Our Case Number: ABP-314724-22

Re: Railway (Metrolink - Estuary to Charlemont via Dublin Airport) Order [2022]
Metrolink. Estuary through Swords, Dublin Airport, Ballymun, Glasnevin and City Centre to
Charlemont, Co. Dublin

Observation on a Strategic Infrastructure Development Application

Client		Project		Drawing Title	METROLINK - GENERAL ARRANGEMENT SAINT STEPHEN'S GREEN	Drawing Status	S0
Consultant		Drawing N°	ML1-JAI-ARD-ROUT_XX-DR-Y-03093	Plan Drawing N°	ML-RO 306 C-D	Sheet 1 of 1	
		Scales Original Size A1	AS SHOWN

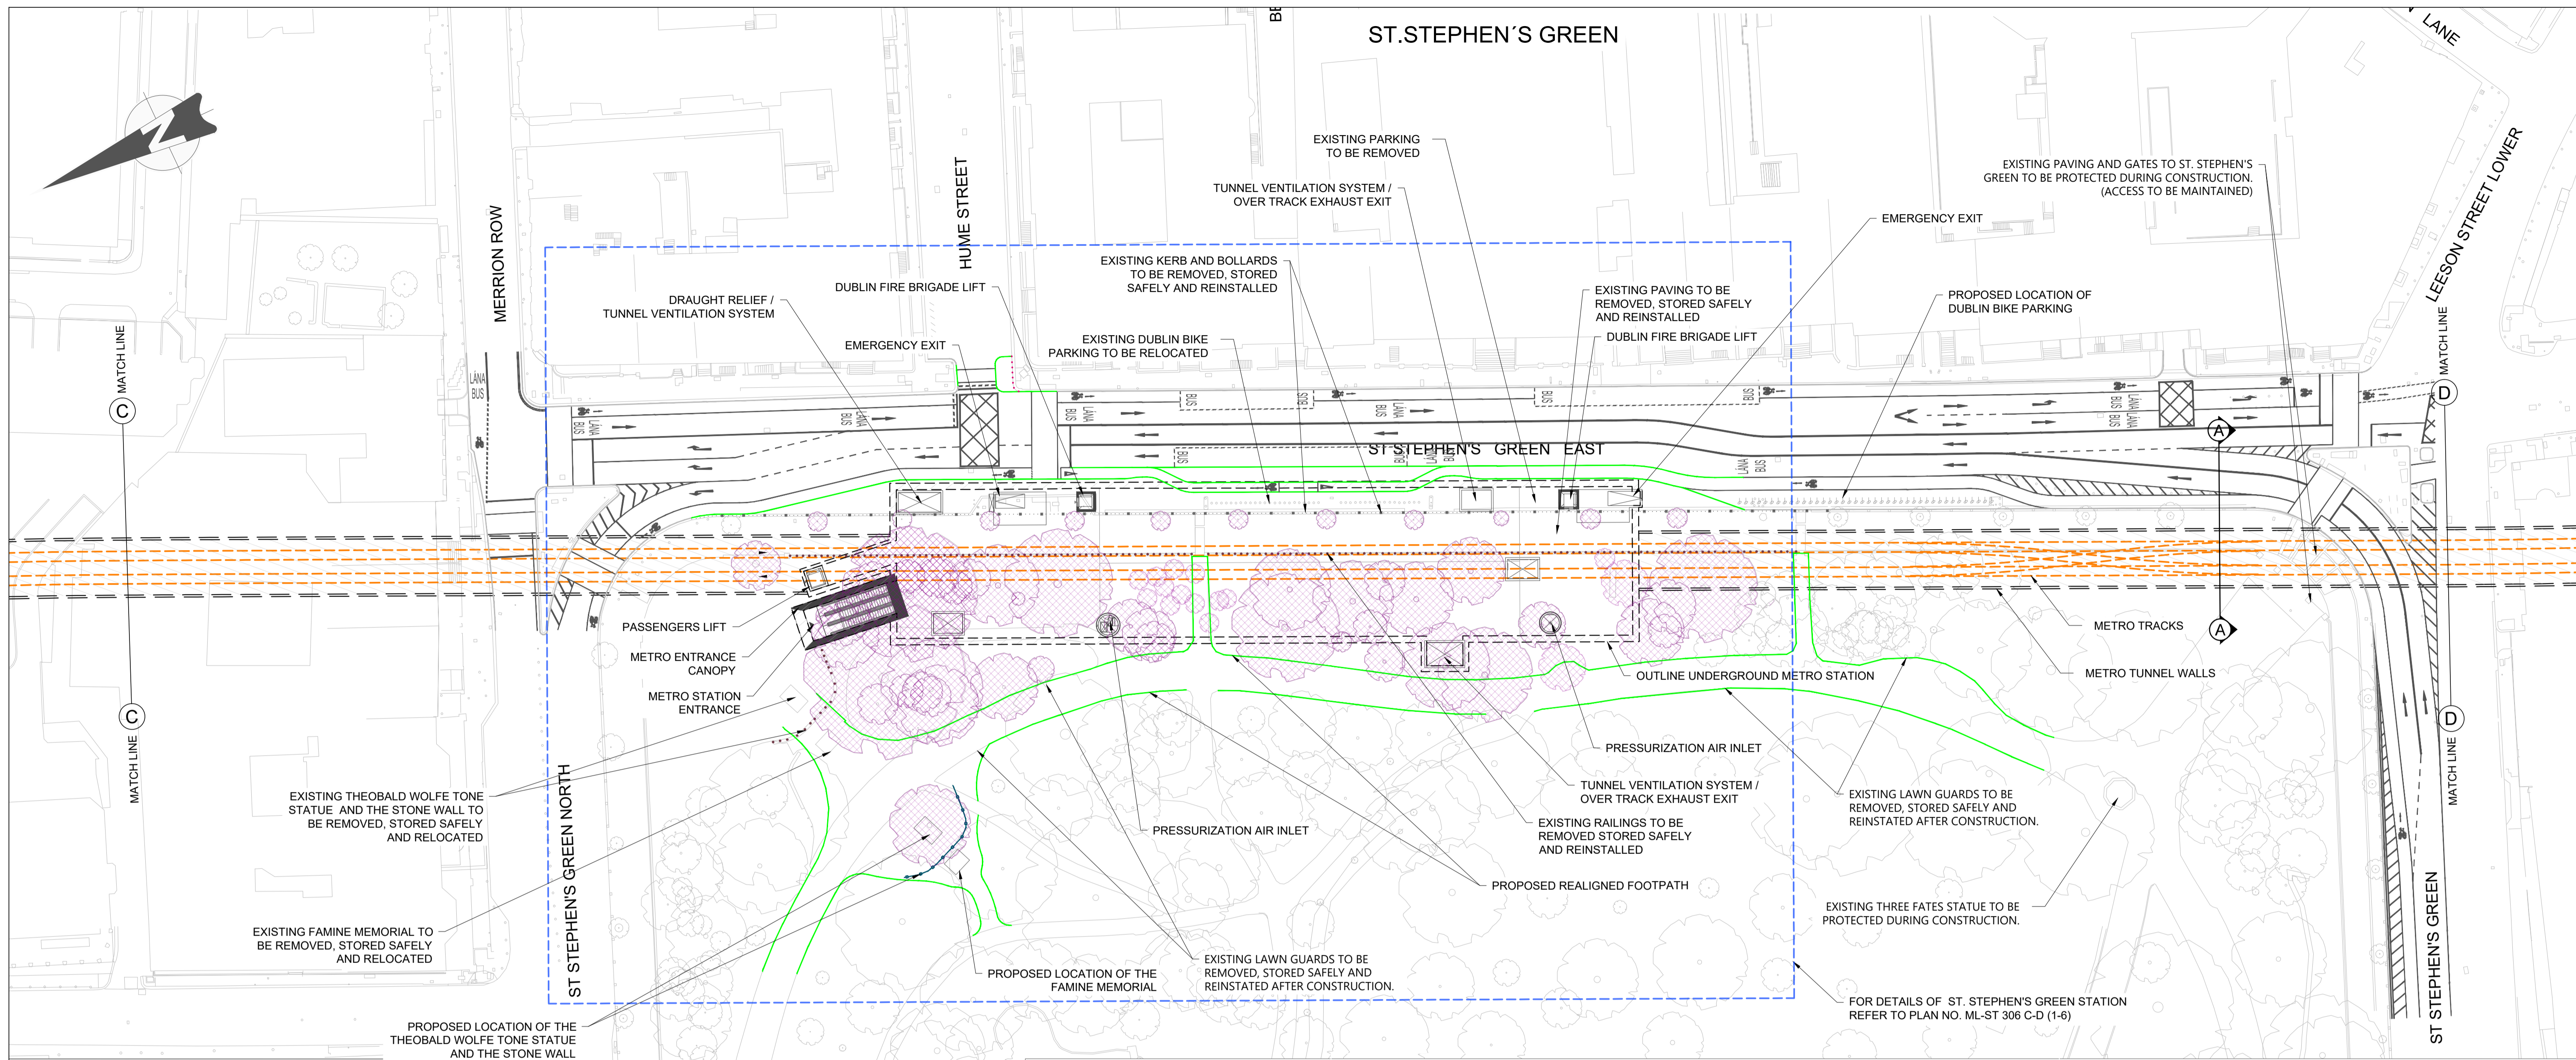
I would like to make an observation regarding the siting of the St. Stephens Green Station: namely the cut and cover works for the station location, as the project does not seem to have balanced the full range of factors that should have been taken into account. It is troubling that any part of Dublin's best loved park could ever be considered as suitable for a major cut and cover project for the station while alongside lies an adjacent wide roadway (St. Stephens Green East) with capacity for the station, its entrances and structures, allowing for a successful and complete re-instatement after the works.

While the potential of the proposal is positive in its increased ease of access to St Stephens Green and potential for urban upgrades associated with the works, it throws this opportunity away by not sufficiently acknowledging how outstanding the urban purlieus of this corner of Dublin actually is.

It's an architecturally ingenious park entrance as much as a sculpture, uncluttered and spare, it is a dignified set piece read against the greenery and huge tree canopies behind. That is a successful urban composition.

There is really nothing convincing in its proposed re-located position, rendered impotent of function and pushed back out of the way.

In the planning report seven options are considered for this station and then in varying degrees dismissed for practical reasons. The impression given is that in certain circumstances anticipated construction problems for Metrolink are more importantly avoided than detailed consideration of the final urban outcomes.

These are not insurmountable issues and the protected structure reason highly questionable. It just seems that it is never stated how important St. Stephens Green is, although perhaps this would take up an entire volume and in arguing that a little damage at one side is really nothing. A well-presented section should be provided by the applicant to include the east side from the houses and basements westwards through the park boundary, showing the entire width of the wide road and double pavement outside the park which would really be a telling drawing to combat the main concerns for pushing into the park.

The felling of trees for such projects is usually understated and in a “cut and cover” project, there are overhanging branches and adjoining roots of retained trees impacted so the neat little box is rarely the actual damage zone. Changes to hydrology locally can be detrimental to mature trees. The imbalance to the composition of the canopy within the park will be a very damaging outcome, it will be an obvious visual and ecological negative and one that can only recover over generations.

The park is regular on plan and in every way as one looks at it, so it has to become clear in the future to anybody looking to admire it or if walking through it, that some traumatic negative event has occurred to unbalance the beautiful composition. The tree canopy cover exceeds its boundary, offering canopy covered sidewalks externally alongside the outer rows of limes and at every season one is stuck by how lucky we are to inherit such a place. While the buildings are more intact and regular on the east side of the green than any other, the significance of its canopy reading as a beautiful counterpoint and balance to them is even more intensely experienced, a sublime effect that could be lost for generations if current preoccupations prevail.
